CITY OF ALBUQUERQUE

September 16, 2021

Re: Sandia Lab FCU
1100 Rio Grande Blvd NW
Traffic Circulation Layout
Engineer's 09-14-2021 (H13-D109)

ENGINEER'S SEAL RONALD R. BOHANNAN P.E. #7868	SANDIA LAB FCU RIO GRANDE + 1-40	DRAWN BY RG
	TRAFFIC CIRCULATION LAYOUT	DATE 10-8-2020
	TERRA WEST, LLC 5571 MIDWAY PARK PL NE ALBUQUERQUE, NEW MEXICO 87109 (505) 858-3100 www.tierrawestllc.com	DRAWING 2012100-SP
		SHEET # C1
		JOB # 2012100

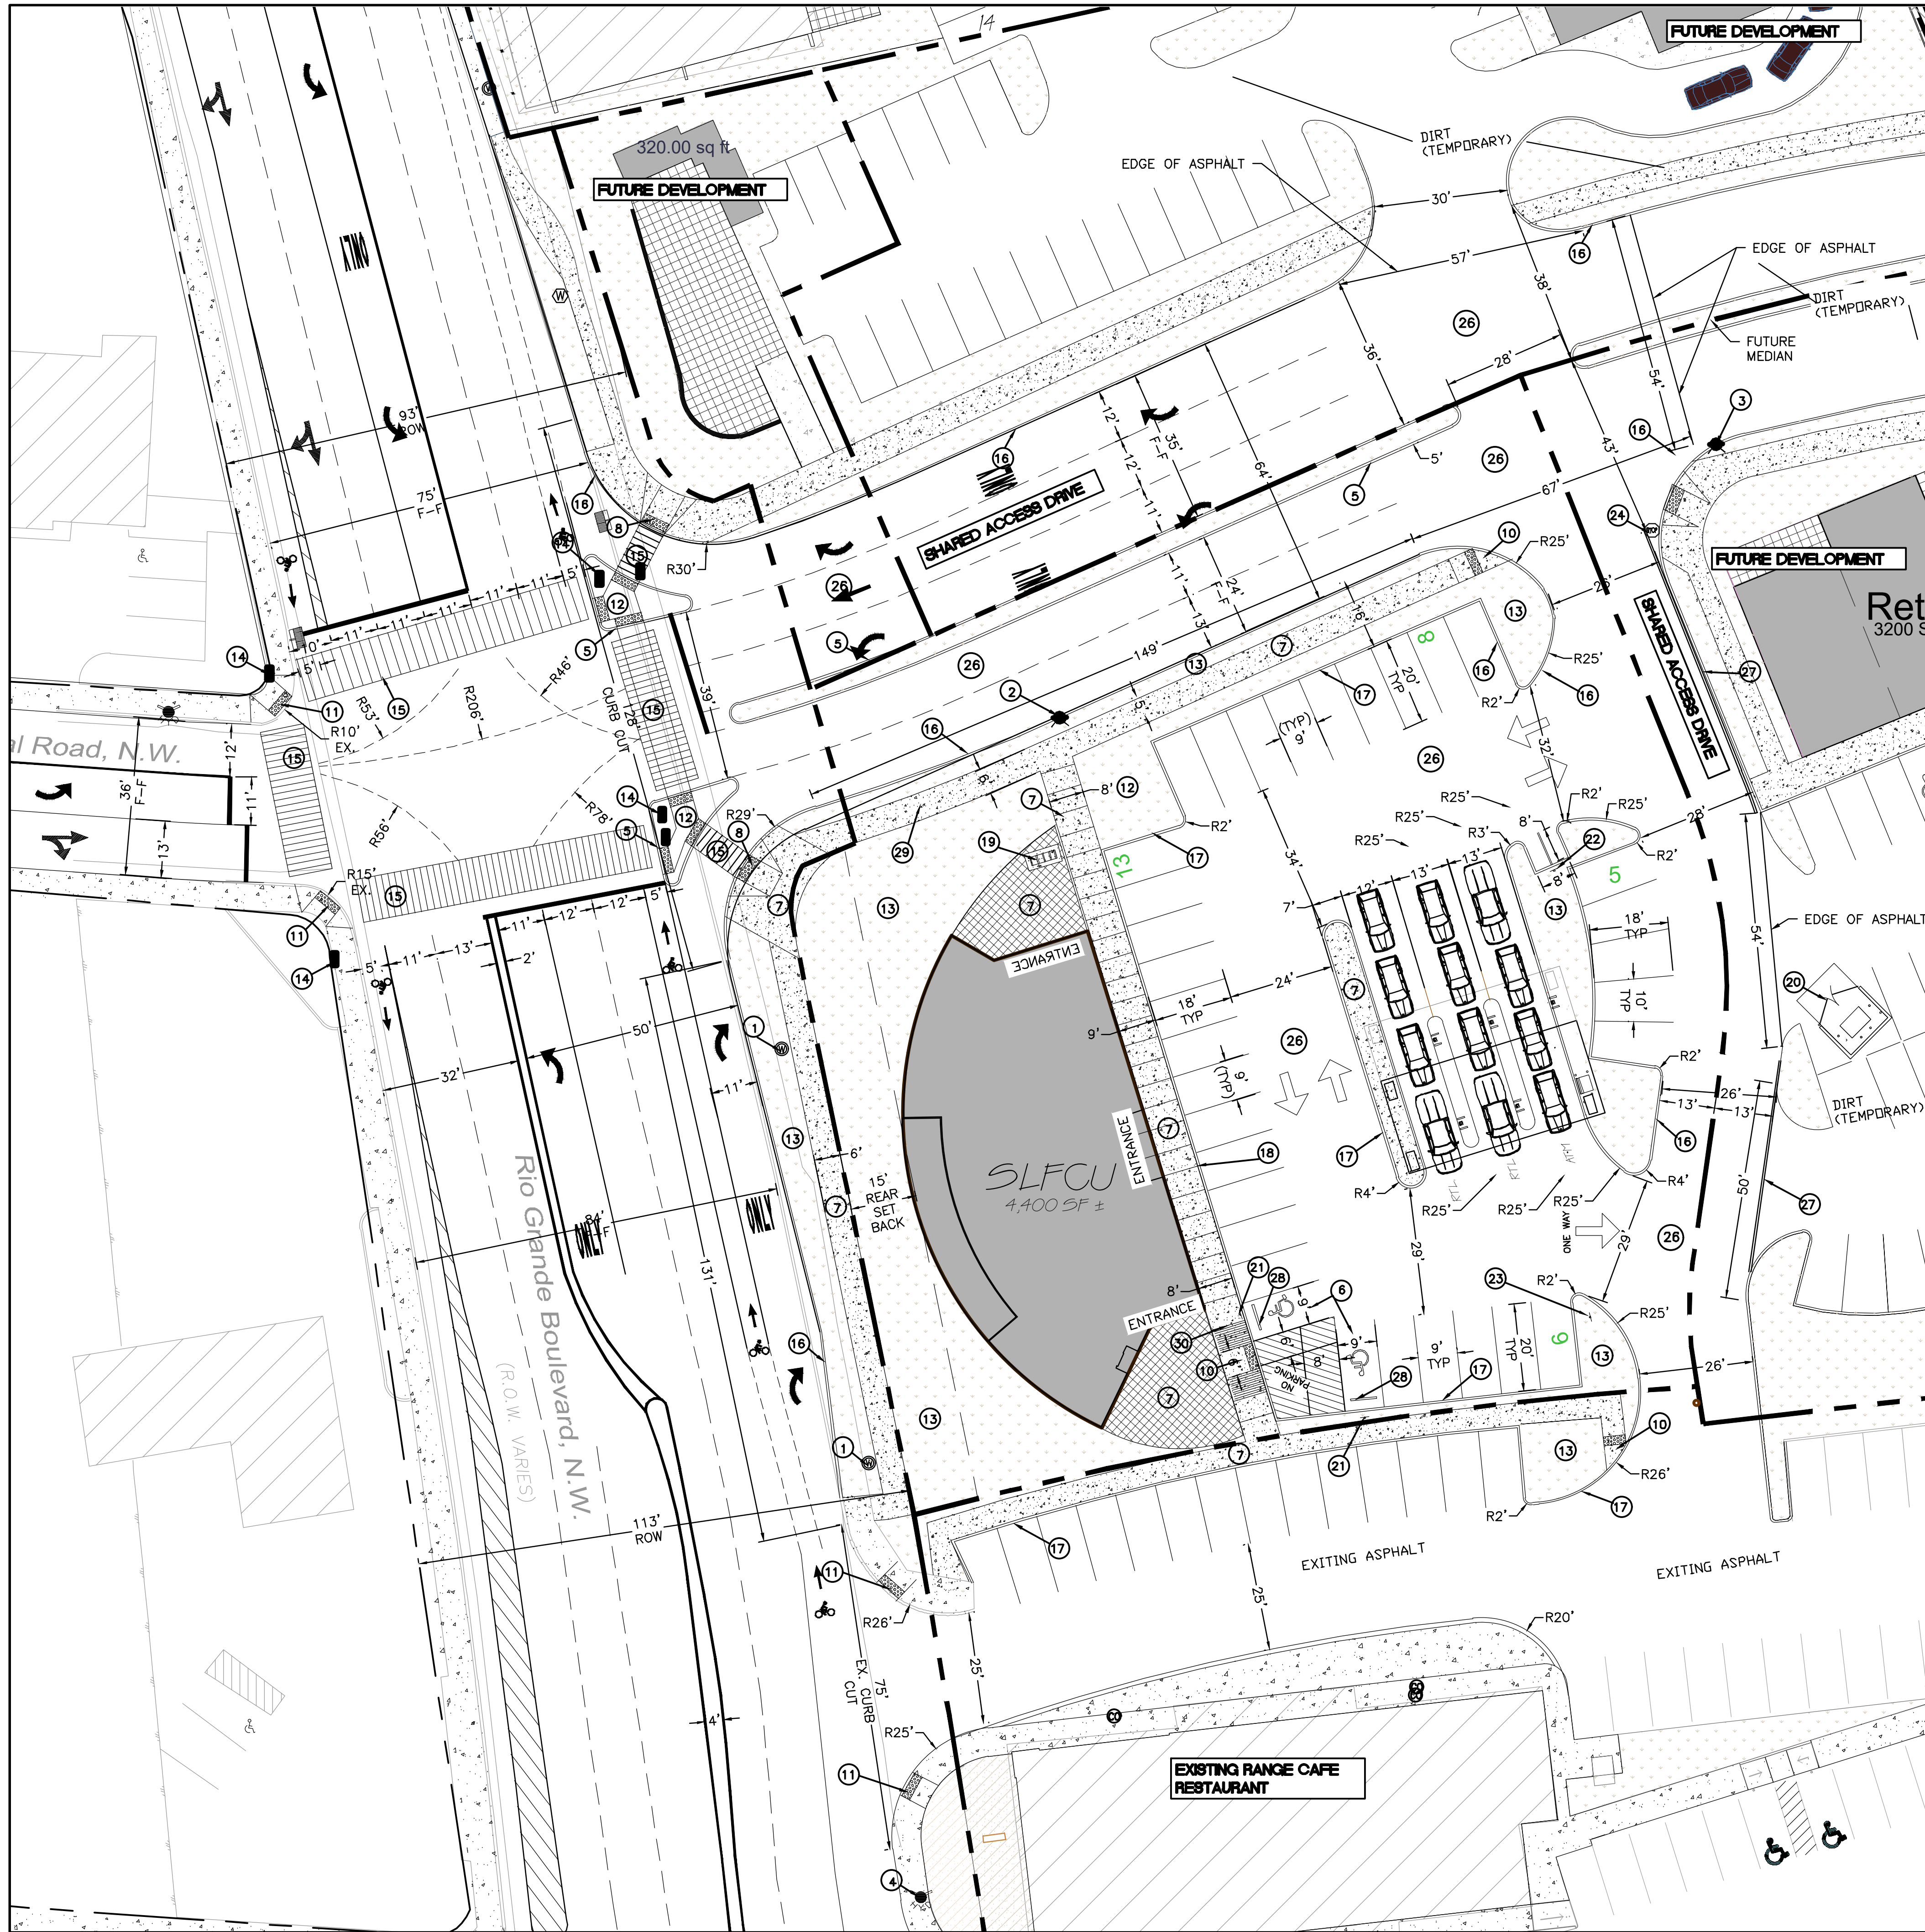
3. **Rio Grande Frontage (Sheet C1):**
 - All construction notes on Rio Grande ROW will need to be removed for TCL submittal that are not pertinent to TCL project.

- Provide/label notes identifying future work order items on TCL sheet.
 - Sidewalk width needs to be shown fronting Rio Grande (6ft min.)
4. **Condition of Final C.O. Approval for TCL Project: All proposed improvements/work on Rio Grande Blvd will need to be Financially Guaranteed.**
